VILLAS AT CLAREMONT

LETTER OF INTENT

DECEMBER 2020

LOI V_1 planning redlines only.pdf Markup Summary 2-16-2021

CLAREMONT RANCH WEST - SKETCH PLAN

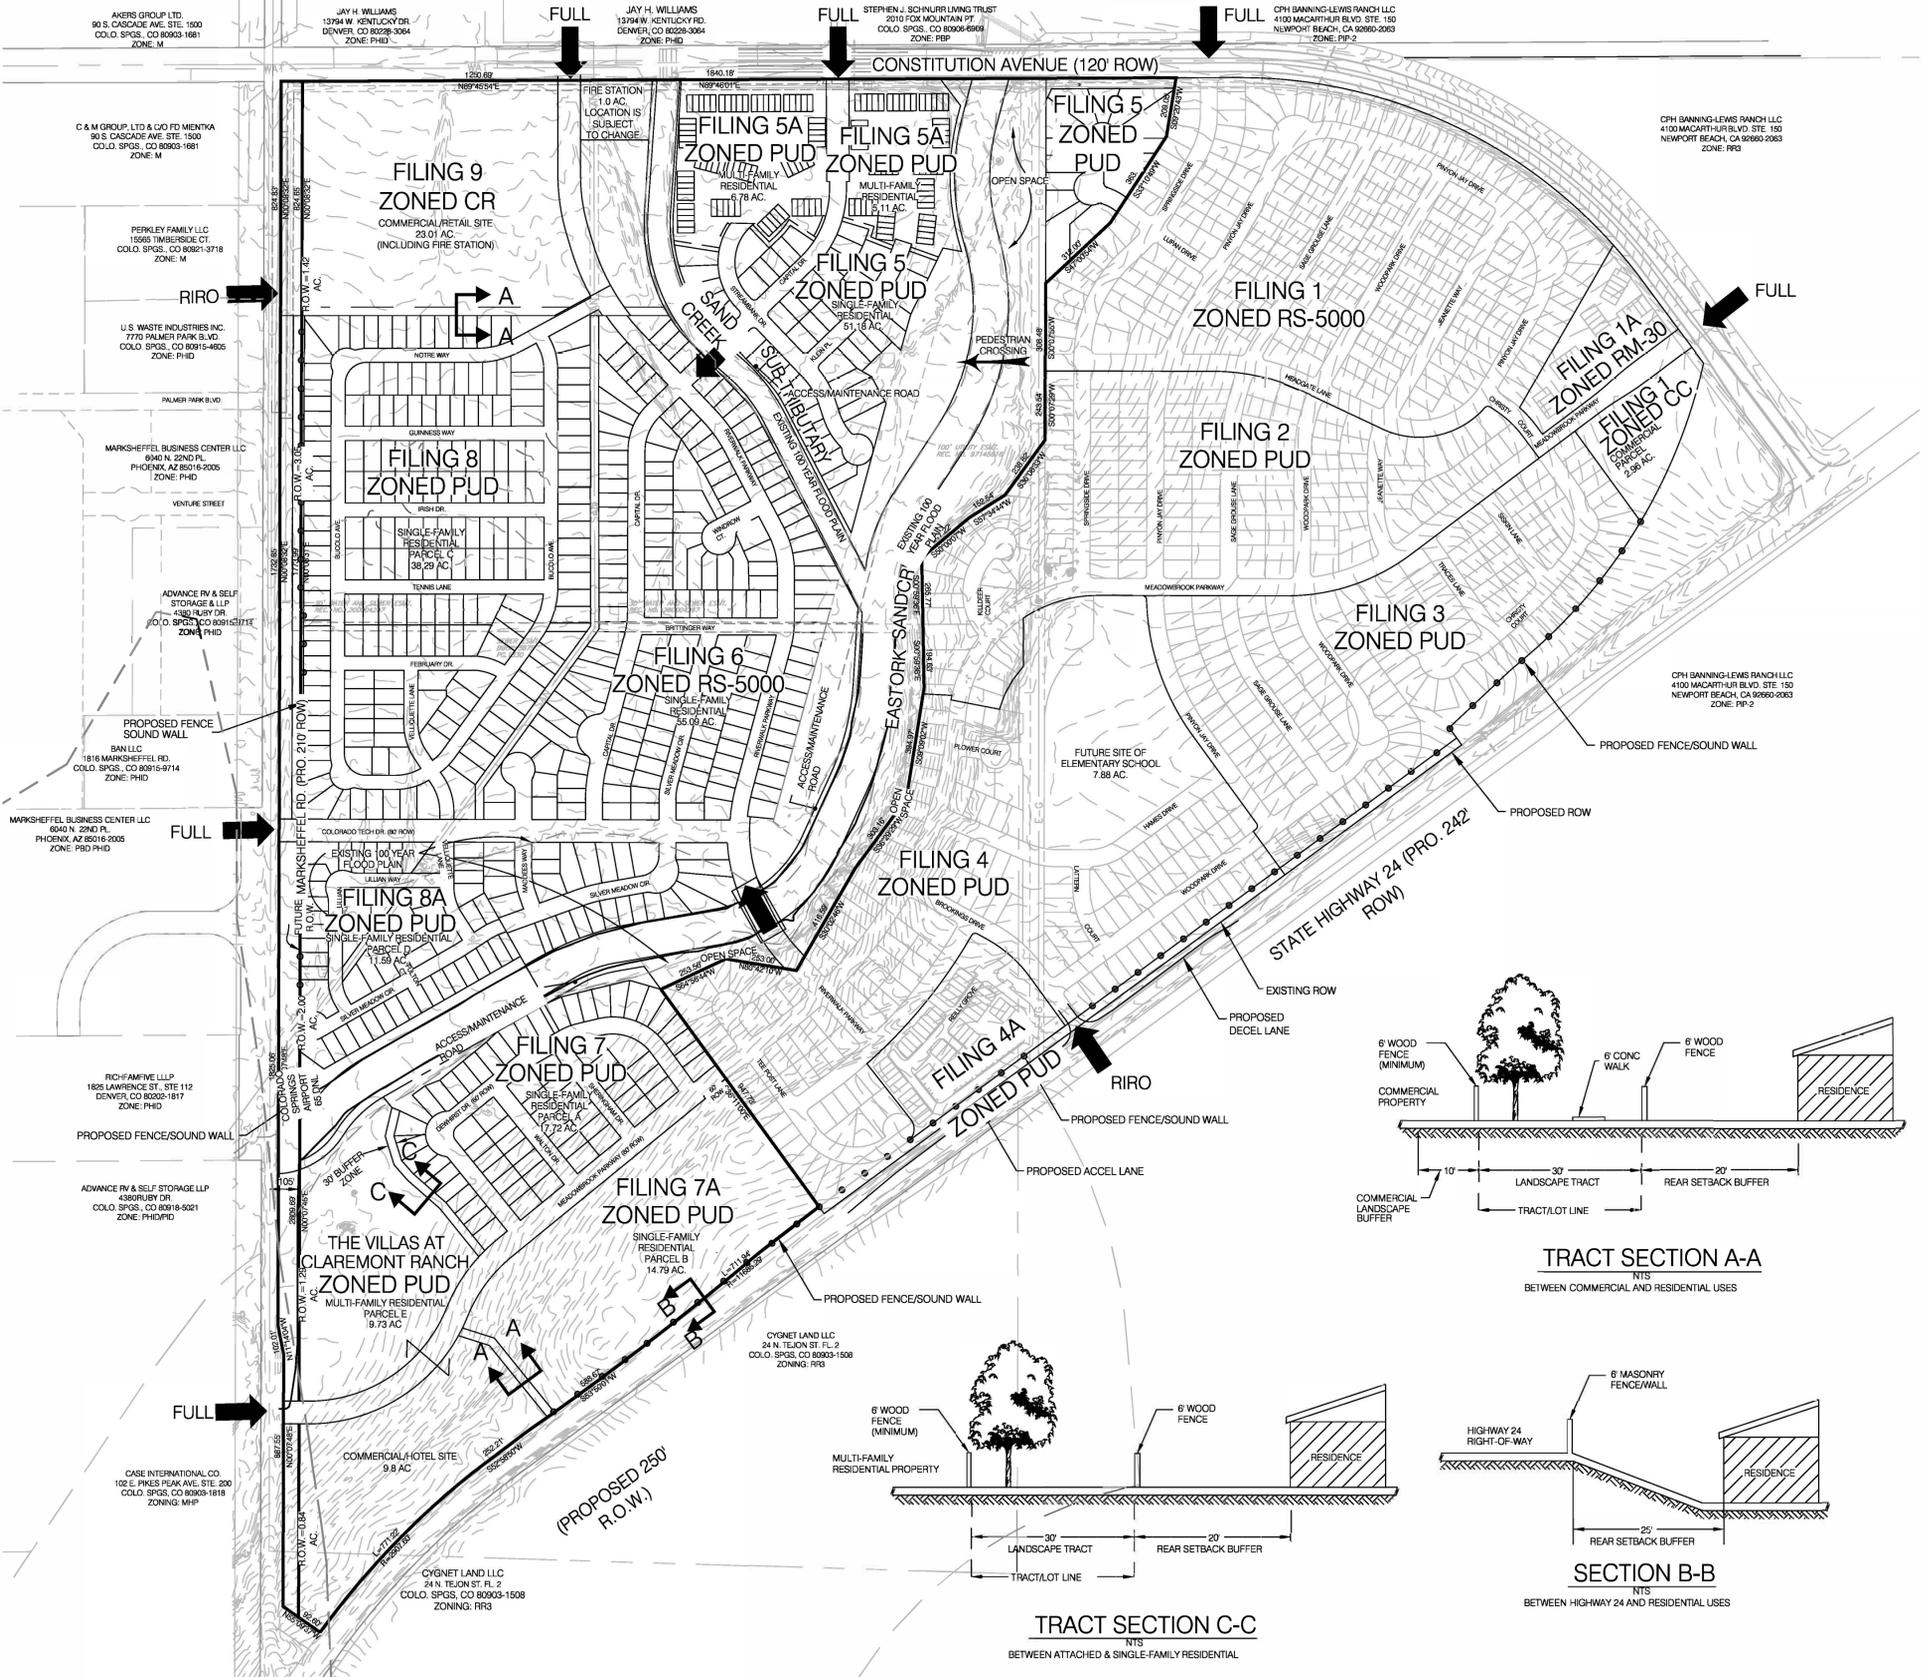
How many acres is the SKP amendment? The revised road alignment is splitting what was to be commercial on the drawing, is the remaining portion to remain commercial?

no tracts are depicted on the SKP so this is a confusing paragraph.

Staff was unable to see these buffers identified on the SKP- There is a 175-setback from the I-3 required but not depicted on SKP.
